STREET IMPROVEMENT PLANS

JULY 2018

SF-17-025

HOMESTEAD AT STERLING RANCH FILING NO. 1

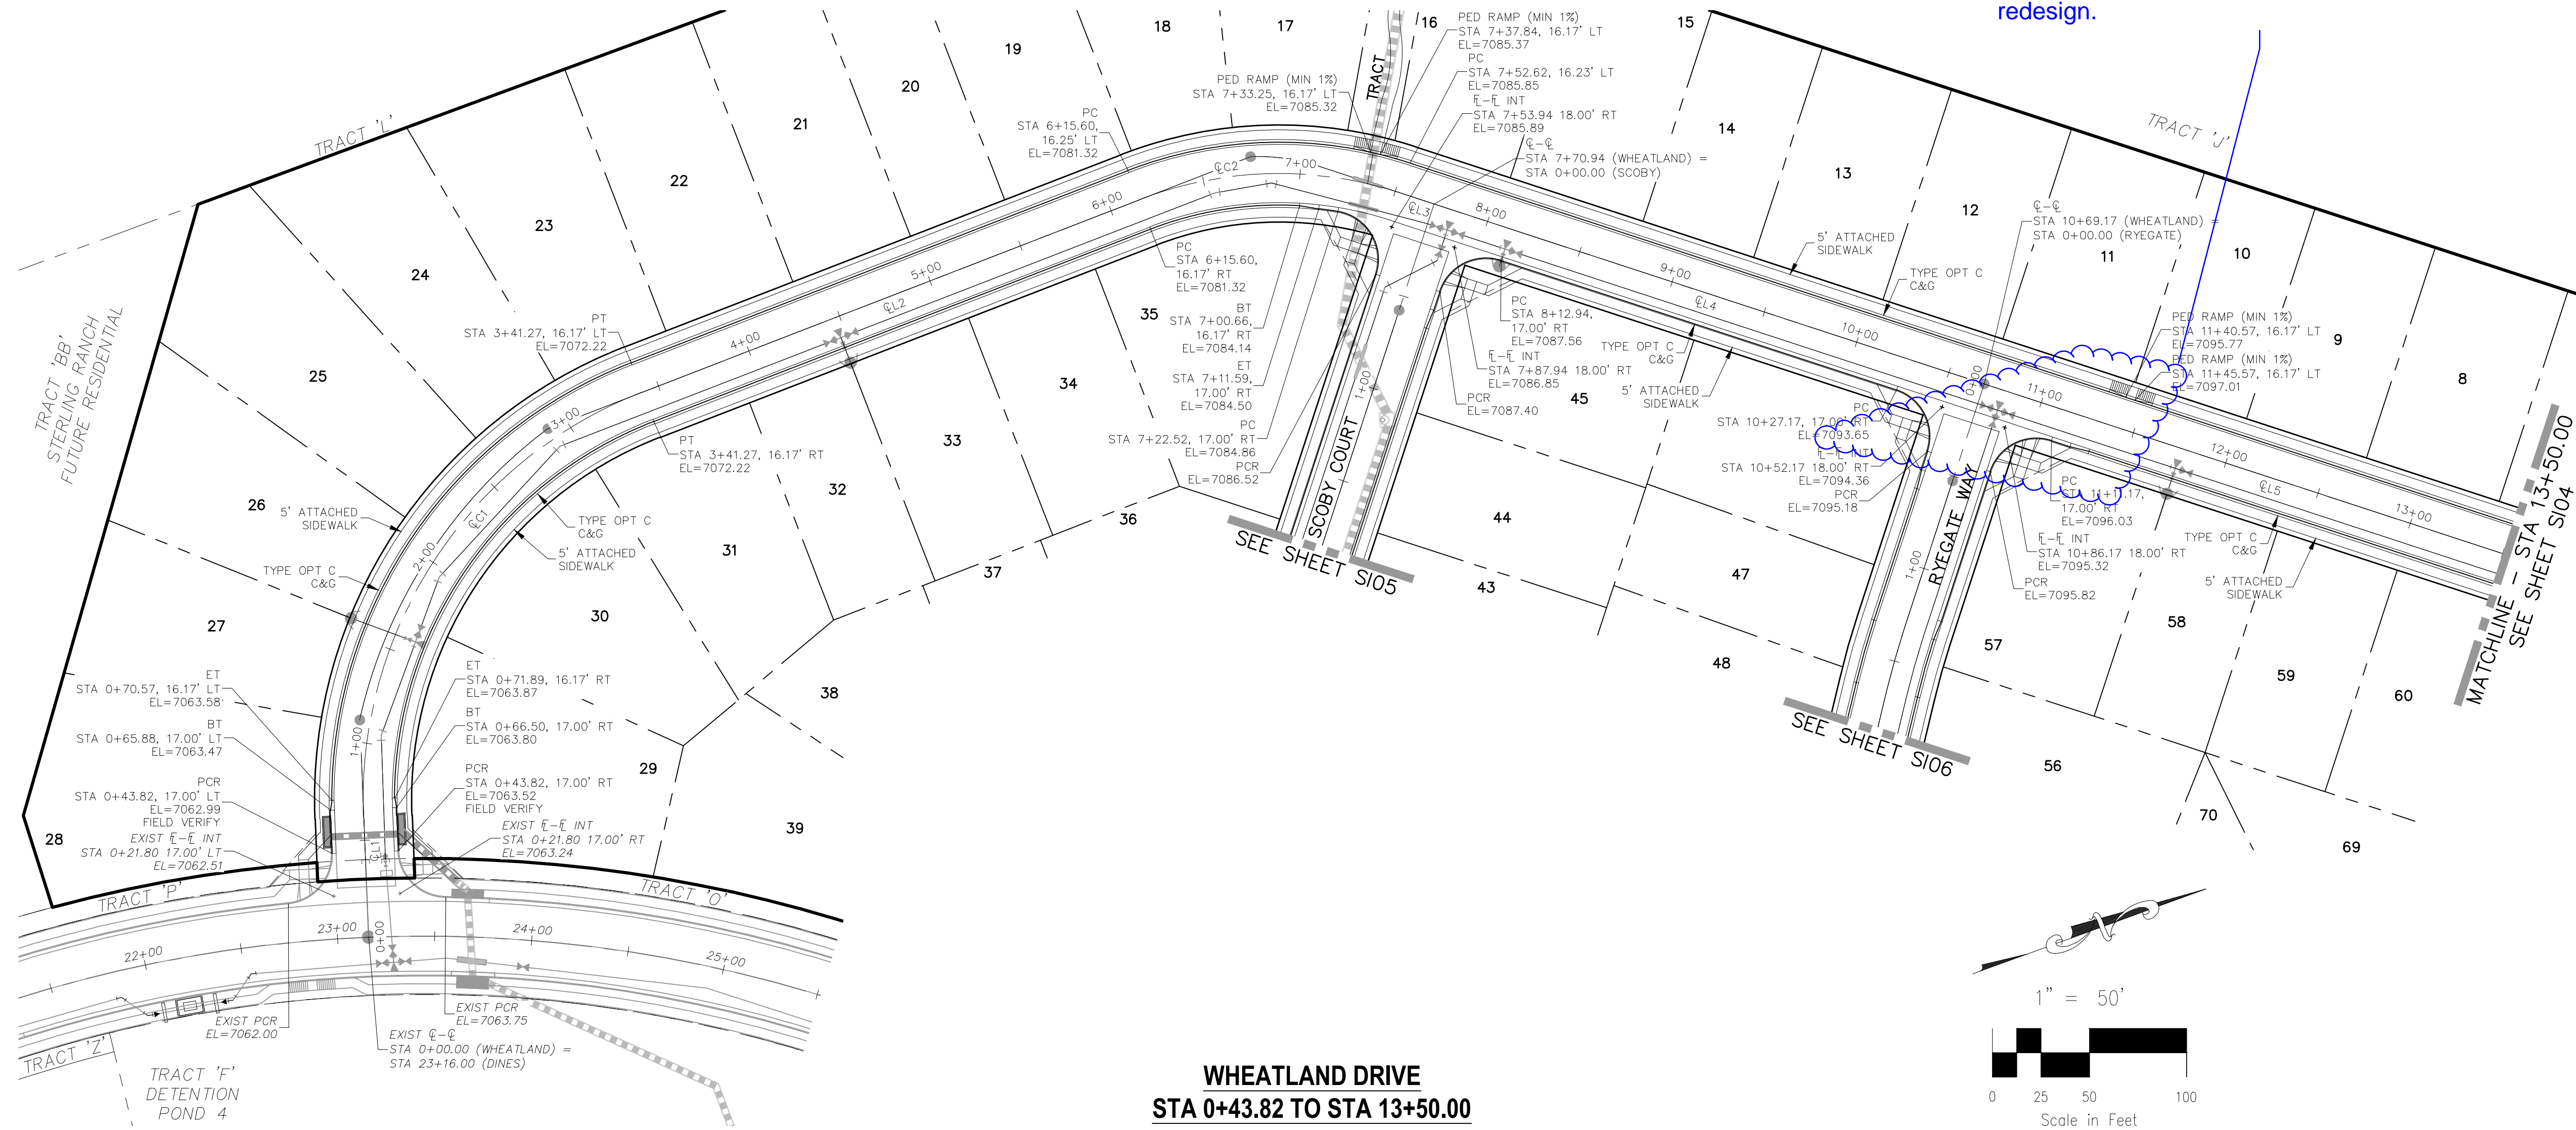
Staff recommends providing complete details on ped. ramps to avoid field issues/potential redesign.

WHEATLAND DRIVE STA 13+50.00 TO STA 17+81.93

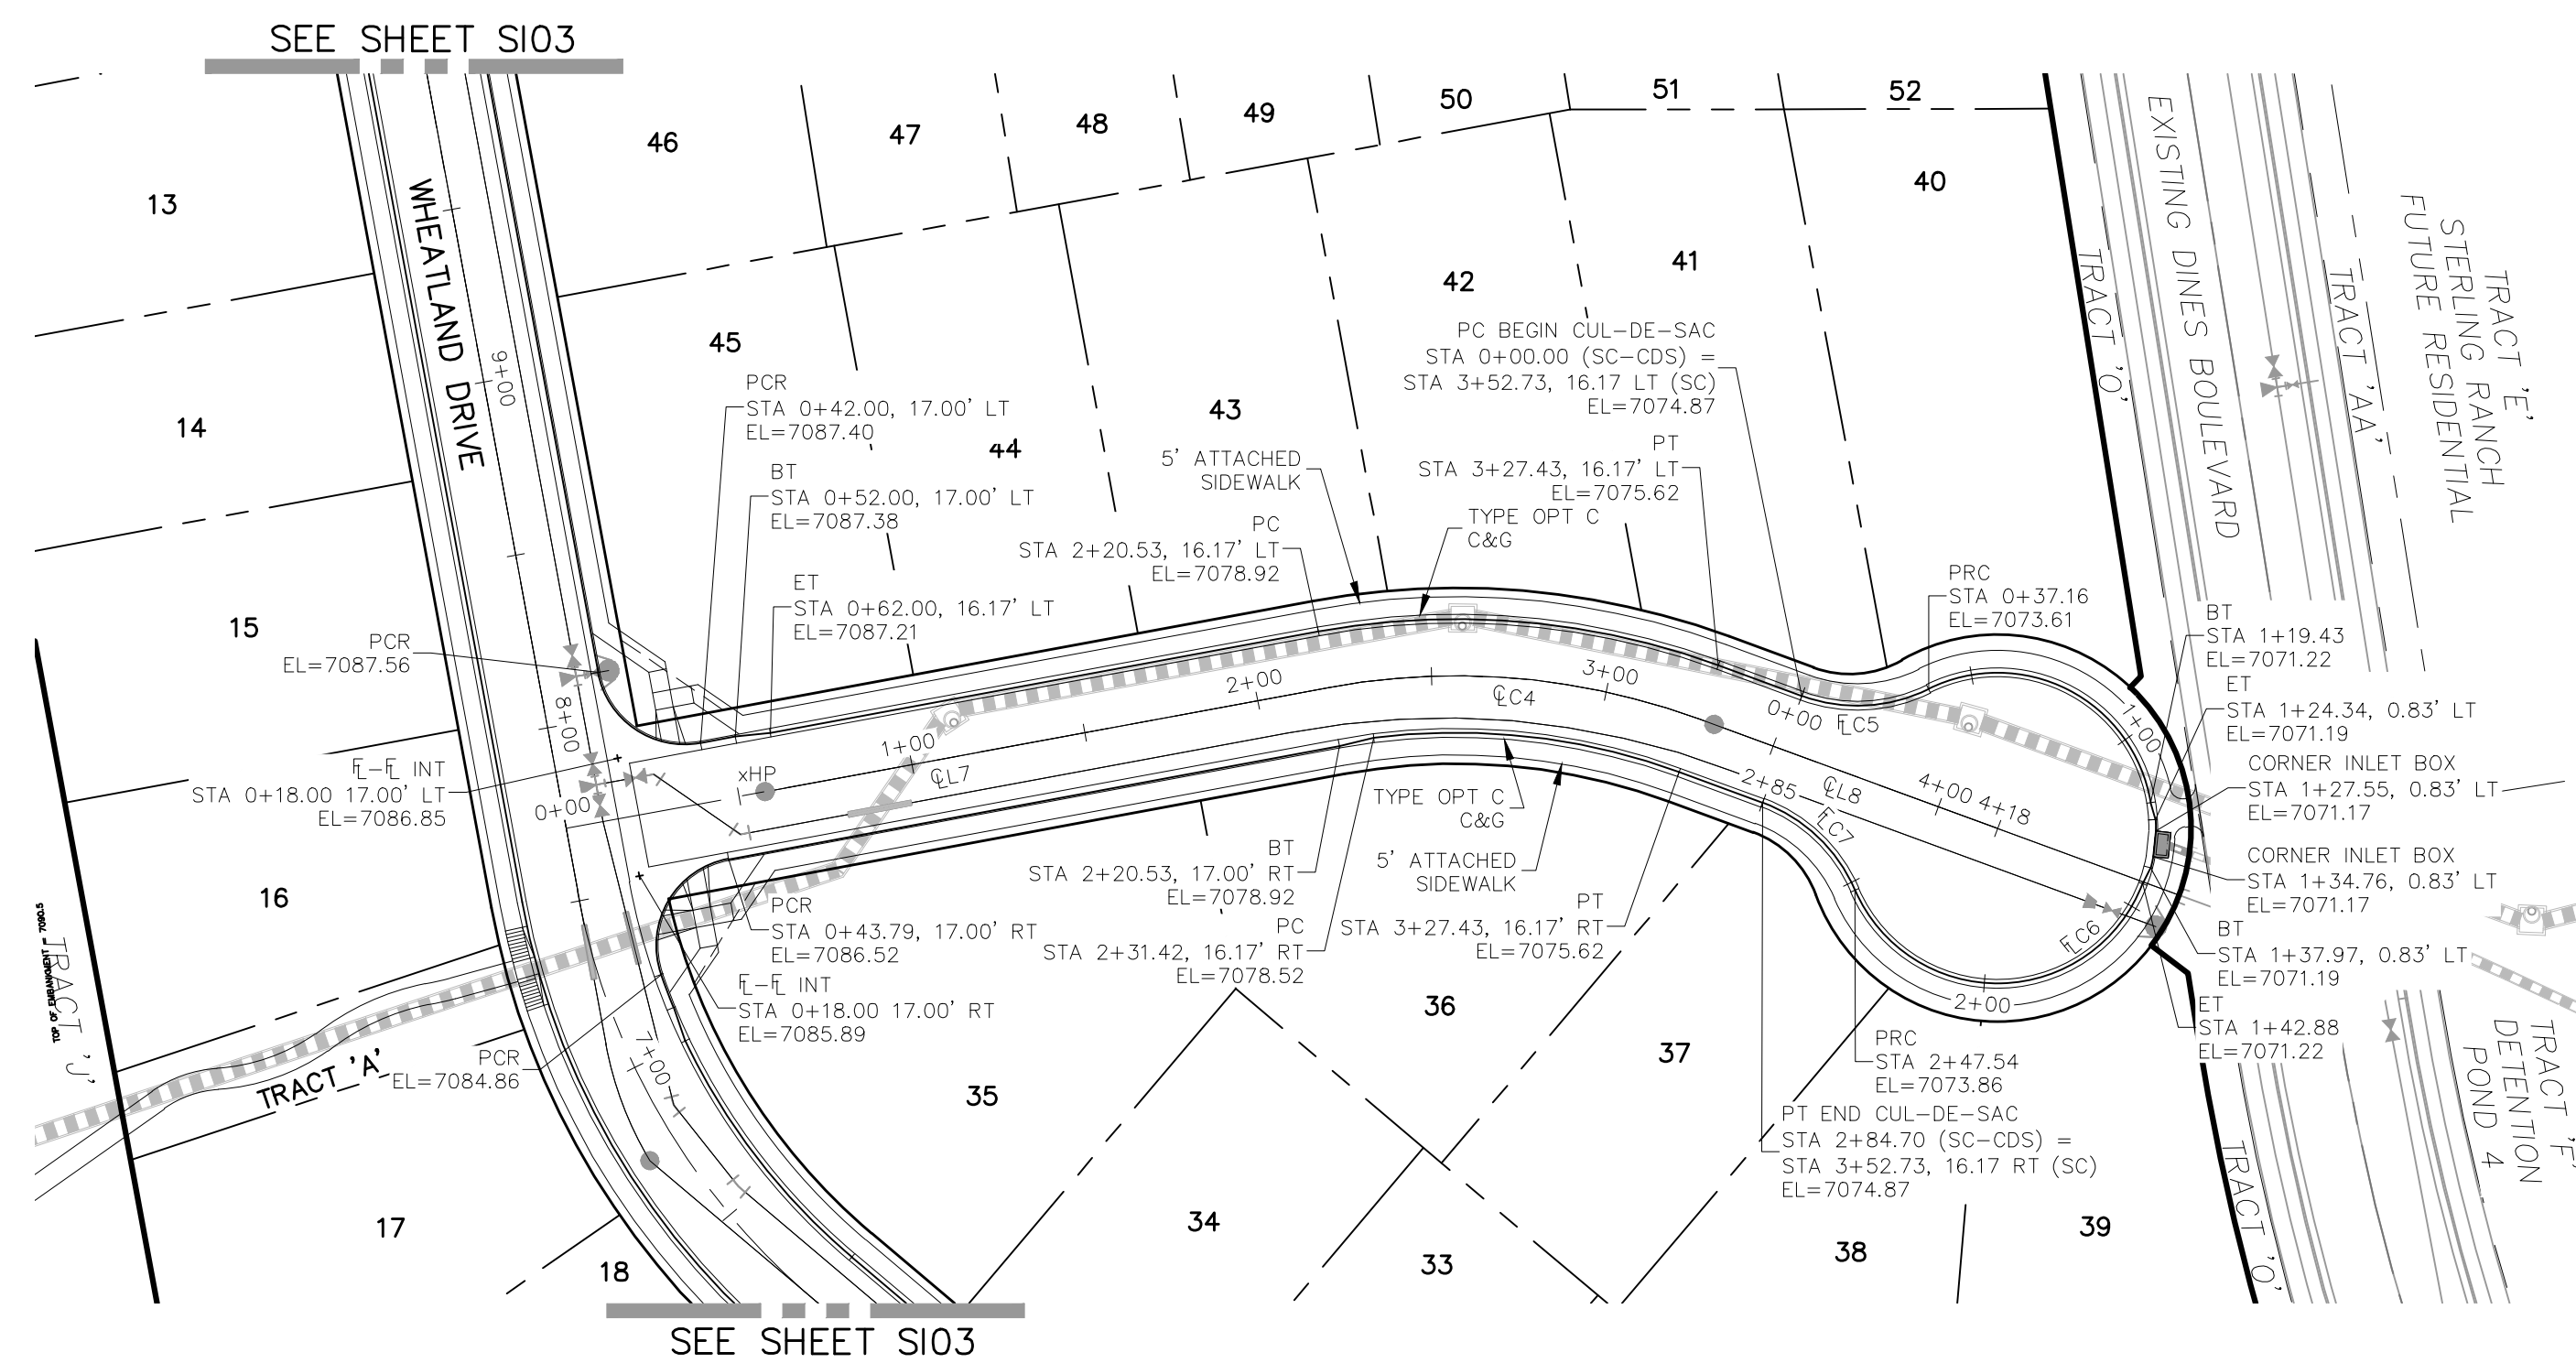
Show grades tying in at all ends of profiles
